Recommendation Report for Lawful Development Certificate for a Proposed Use or Development

REF NO: A/52/21/CLP

LOCATION: 9 Horton Place
Angmering
BN16 4GL

PROPOSAL: Lawful development certificate for the proposed installation of set of bi-fold doors on side of existing garage to be used as garden room.

PR PLAN 01

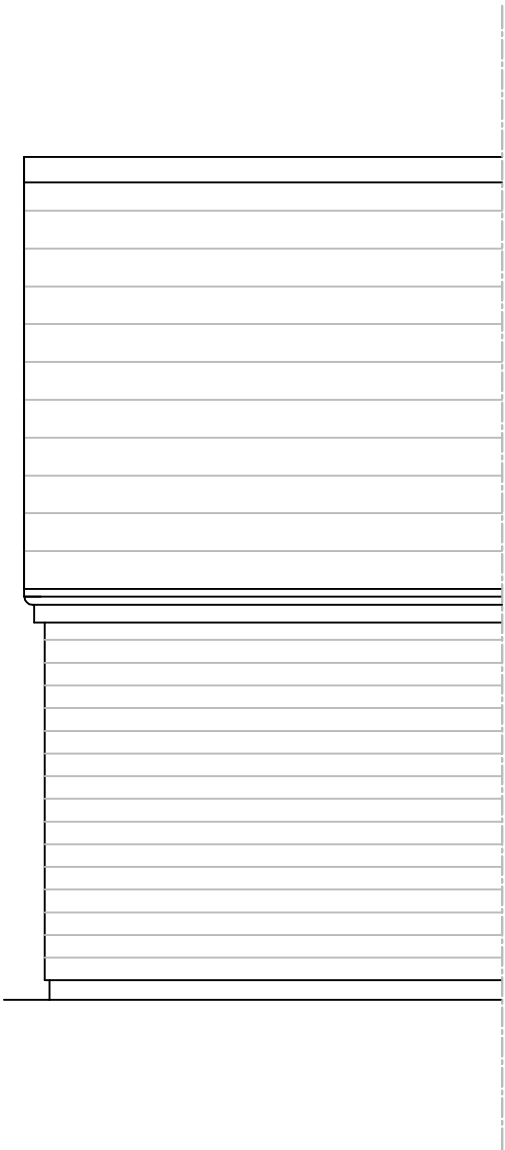
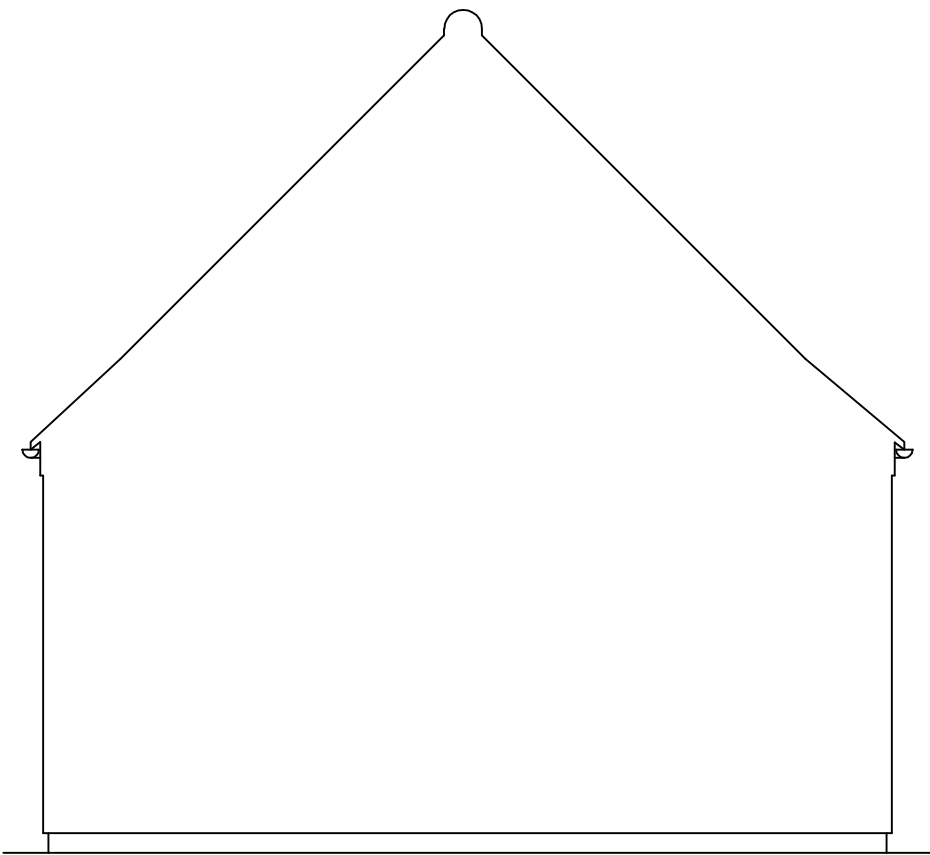
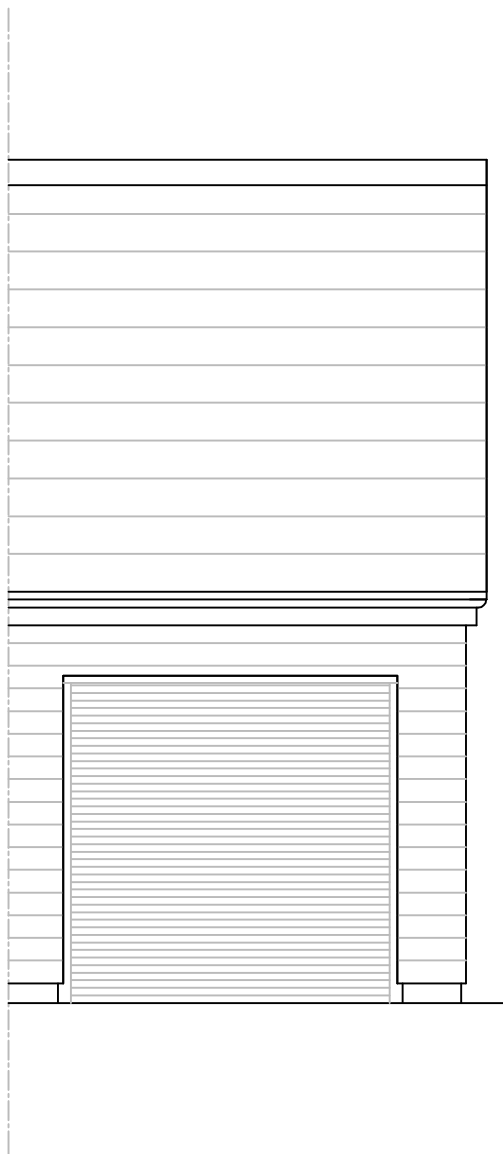
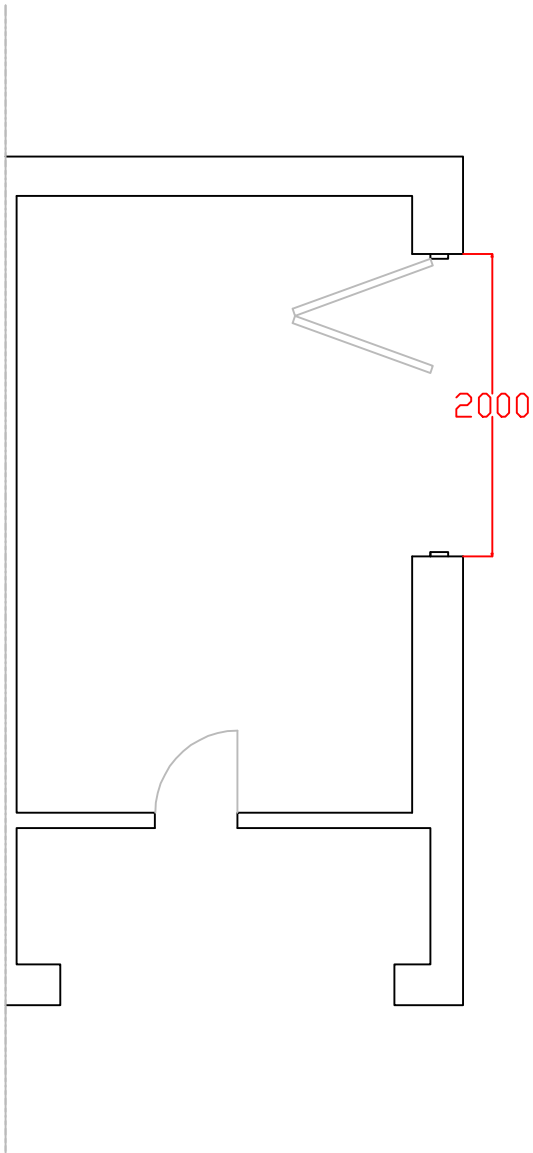
Whilst the proposed external changes to the garage conversion comply with relevant sections (a),(b),(c),(d),(e),(i),(j)(i)(ii)(iii), (k) and are considered to be "Permitted Development", the proposal does require the submission of an application for full planning permission because Condition 4 of outline planning permission A/124/95 for the estate stated:

The buildings shall not be occupied until the parking spaces/turning facilities/and garages/s have been provided and constructed in accordance with details to be submitted. The areas of land so provided shall not thereafter be used for any purpose other than the parking/turning/and garaging of vehicles.

The proposed conversion of the garage therefore requires the submission of an application for planning permission since permitted development rights have been taken away by the imposition of the above condition.

REFUSE
